CITY OF PORTLAND BUILDING PERMIT

PERMIT ID: 2013-00371

80 WILLIAM ST

has permission to **Kitchen and first floor bathe remodel.**

FOOTING DETAIL:

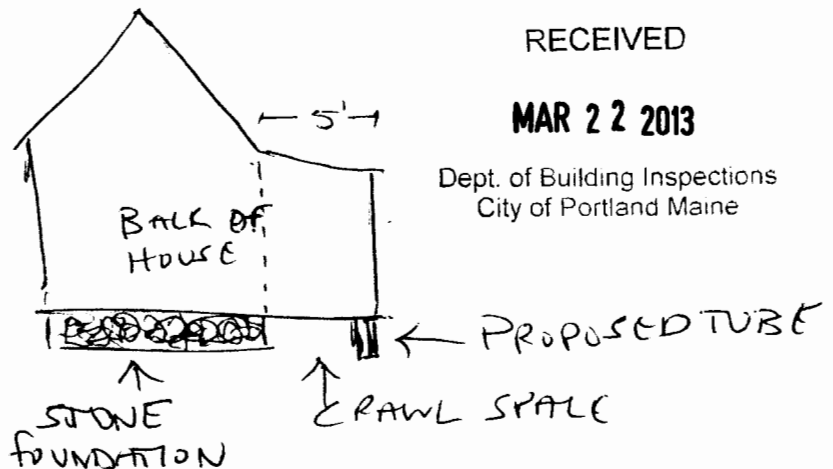
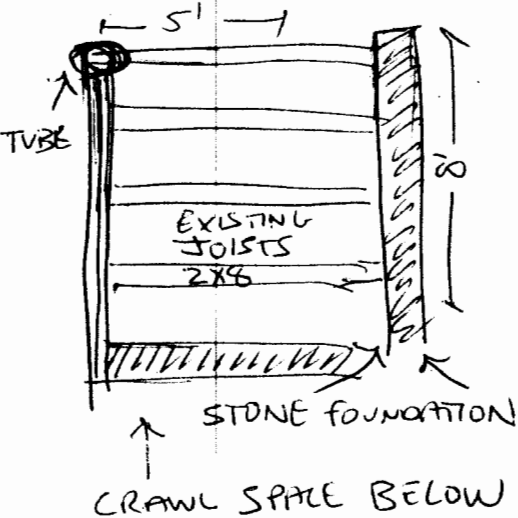
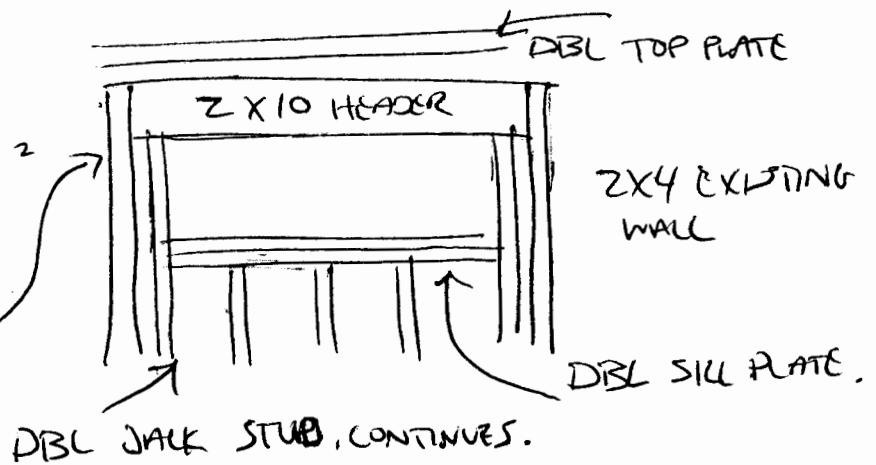
- Is the existing stairwell being renovated at all; is the storage room under an second floor stairwell?
- Draw a floor plan showing where the kitchen is in relation to the remainder of the building
- How close is the window opening to the property line, is the header on a bearing wall/ how many floors above?
- Draw the existing "steel footing" vs the proposed "Sona tube", why is this being replaced?
- What is the headroom/ fixture clearances in the proposed bathroom; is there a window or ventilation?
- Does the existing structure have smoke and carbon monoxide detectors?

- 1) Section R317 Protection of Wood and Wood Based Products against decay. All wood framing members that rest on concrete or masonry exterior foundation walls and are less than 8 inches from the exposed ground.

- 4) Frost protection must be installed per the enclosed detail as discussed w/owner/contractor (at least 4' from grade).

REPLACEMENT OF EXISTING STEEL COLUMN WITH
12" SONA TUBE CONCRETE FOOTING 48" BELOW GRADE.

-The existing 4" steel tube footing has rusted and sunk, presuming it's not below frost level. New sona tube would be on undisturbed soil 48" below grade, 12" width and will support pressure treated 6"x6" post attached with Simpson post base.

-80 WILLIAMS KITCHEN REMODEL-

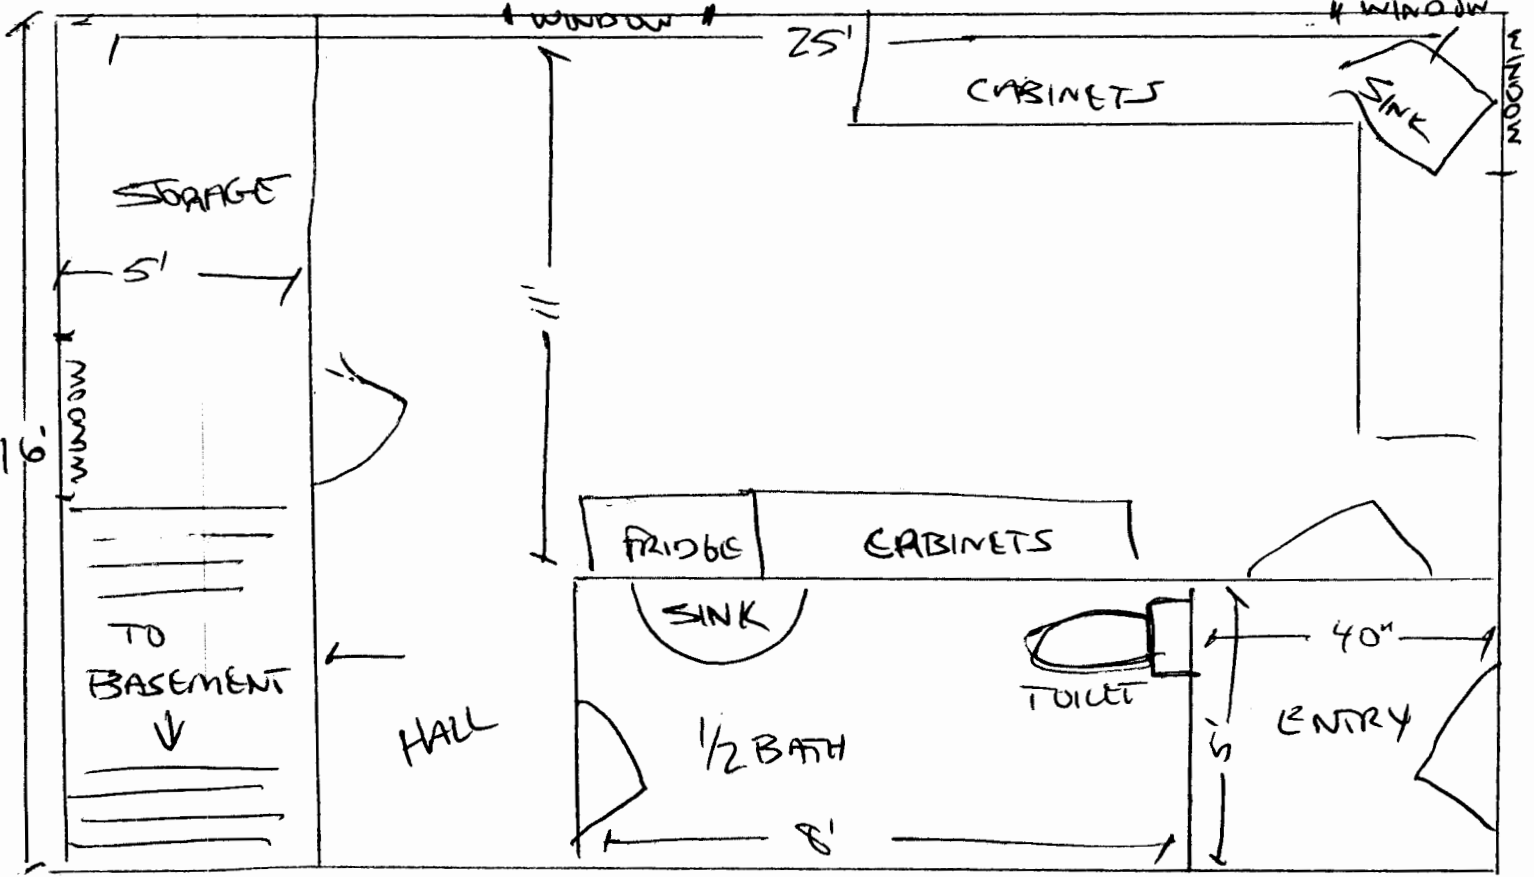
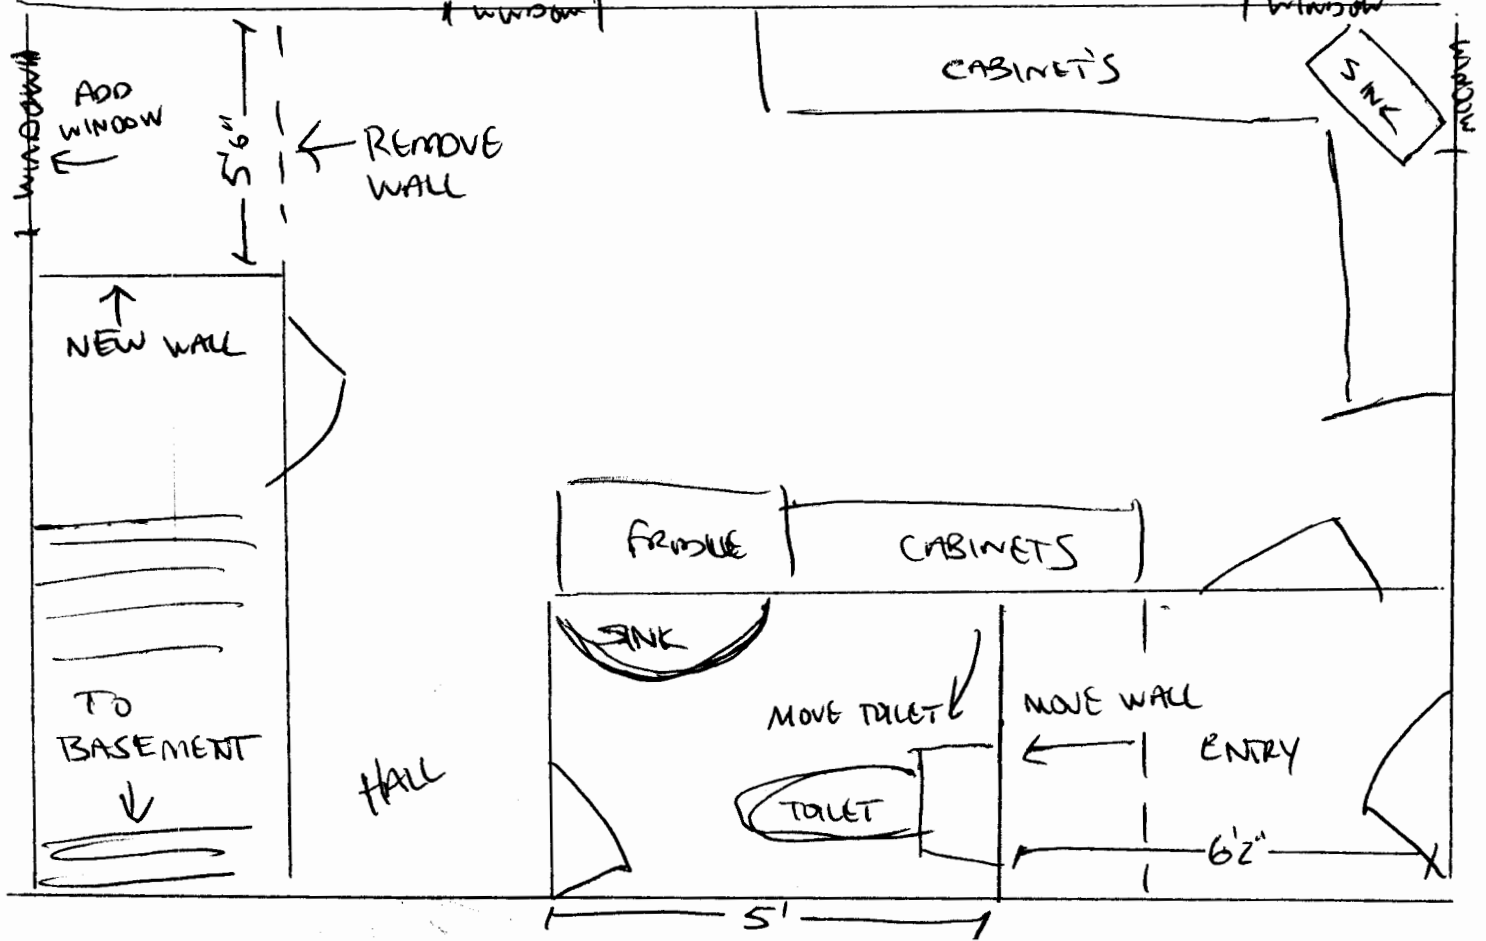
- 2) Note: Window & openings 25% maximum of wall area for less than 5 feet from the property line. Contractor will use (2) 2 x 10 inch for the 48 inch window open (supporting roof and ceiling), and provide mechanical ventilation for the bathroom. Contactor stated that the bathroom fixtures will meet clearance requirements, and he will submit specification for the footing/ pier and rim joist once he assesses the decay.

-The new window (non-operational) would be four feet from the property line. The four foot header is bearing the weight of only a short roof, no second floor.

-The head room in bathroom is 96". The exact layout of sink and toilet in the remodeled half bath is still up in the air with homeowner, we will be sure to meet the fixture clearance codes upon layout. The bath is in the middle of house, therefore no window or bath fan. Is ventilation required without shower?
